PIKE SOLAR GRADING, EROSION & SEDIMENT CONTROL PLANS

EPC STORMWATER REVIEW COMMENTS ARE SHOWN IN ORANGE BOXES WITH BLACK TEXT

PCD-ENGINEERING REVIEW COMMENTS IN BLUE BOXES WITH BLUE TEXT

PIKE SOLAR
EL PASO COUNTY, COLORADO
GRADING & EROSION CONTROL PLANS
COVER SHEET

SHEET
70 OF 77

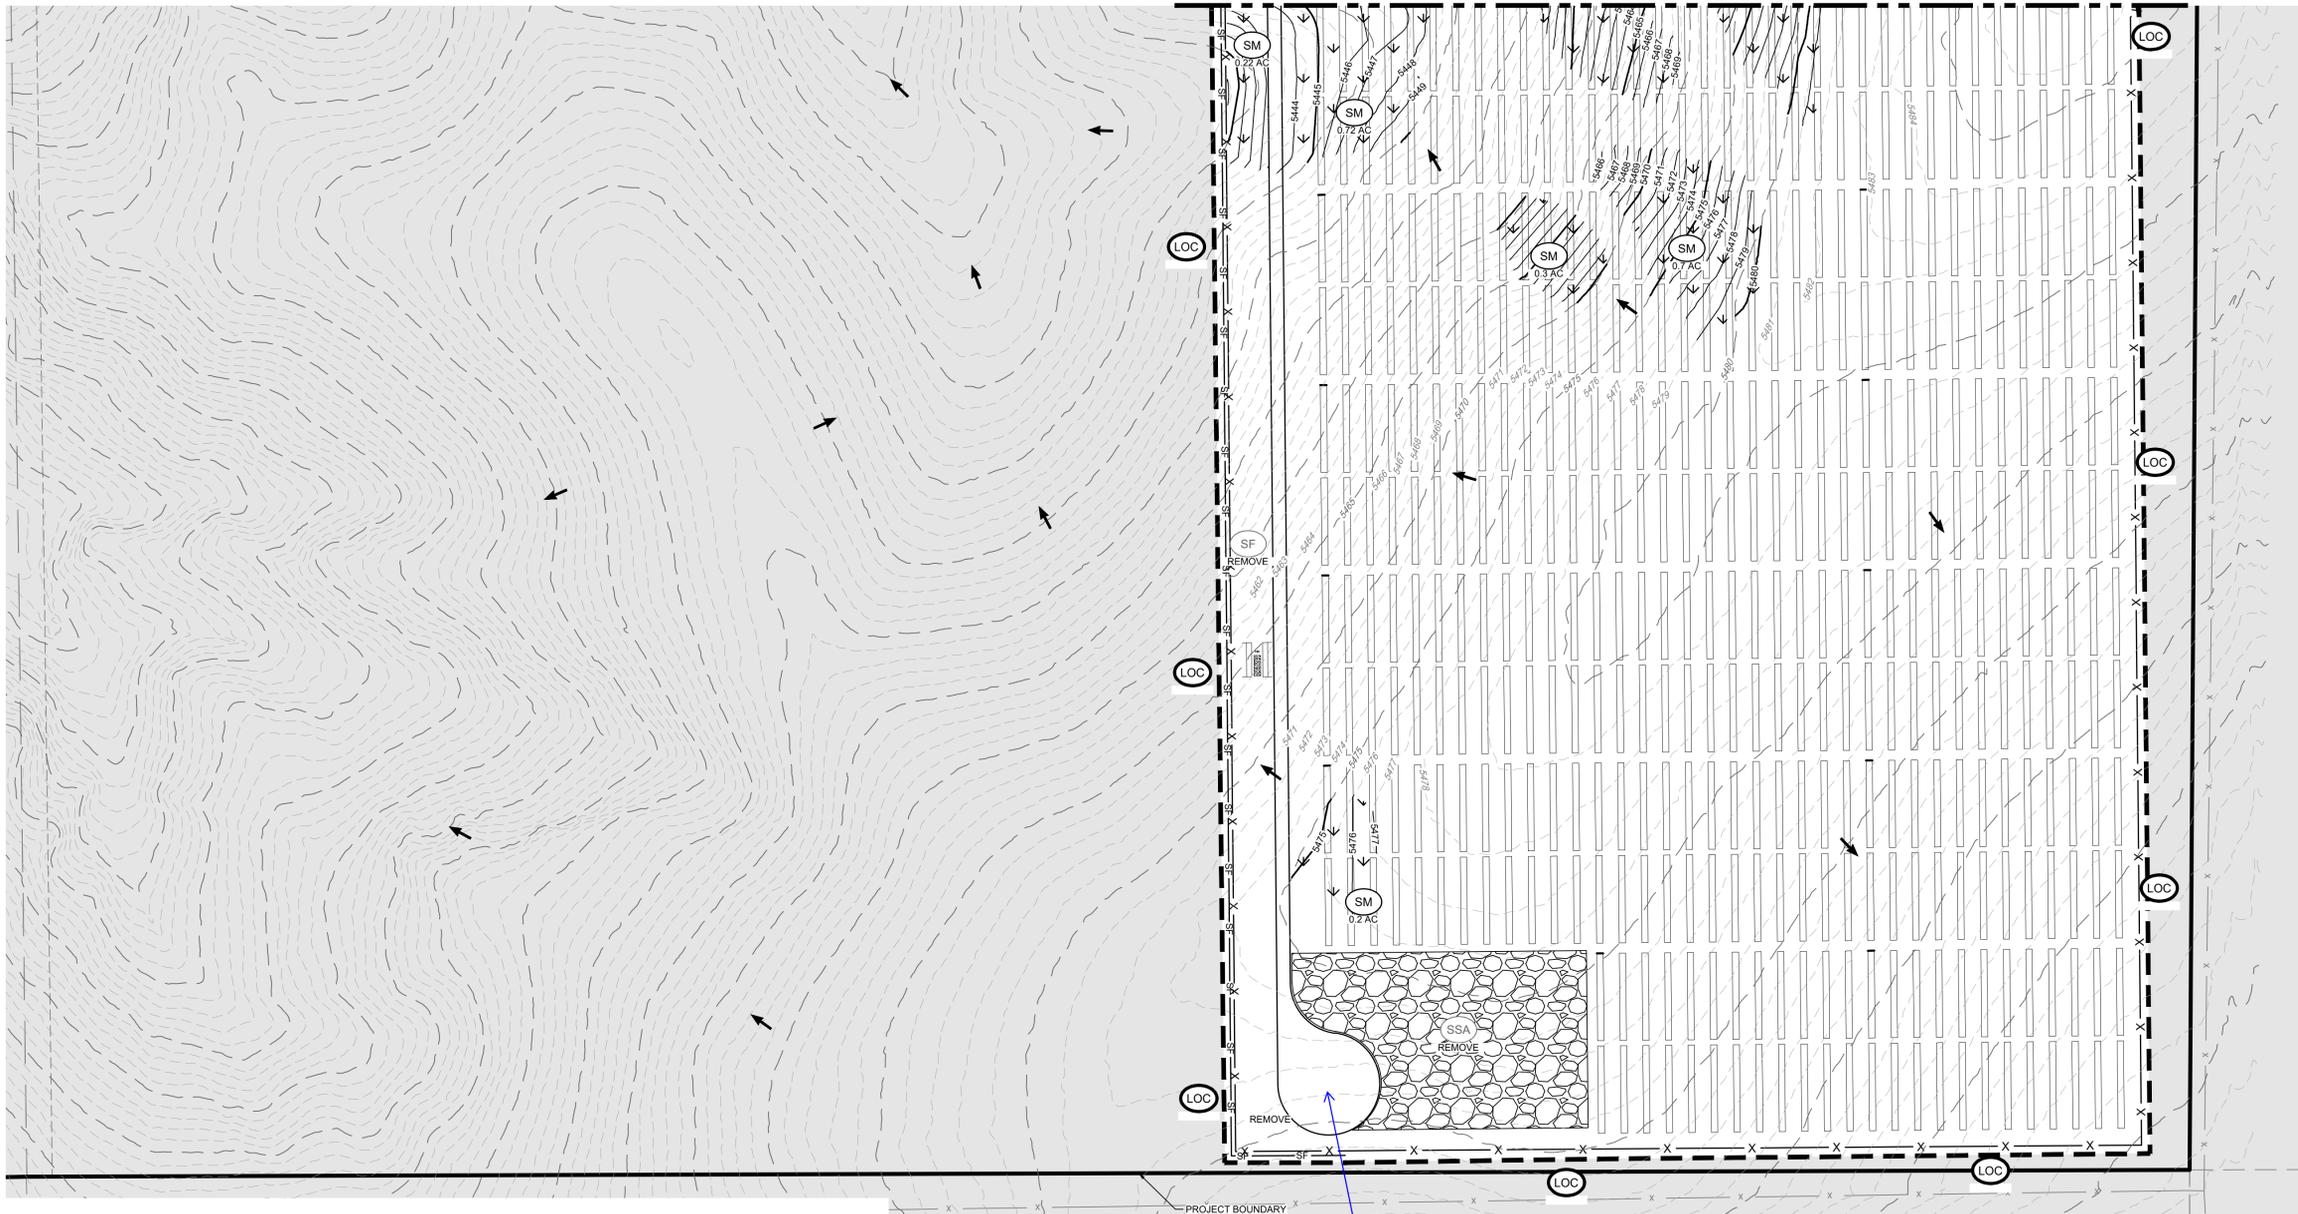
Please provide hatching for permanent access roads
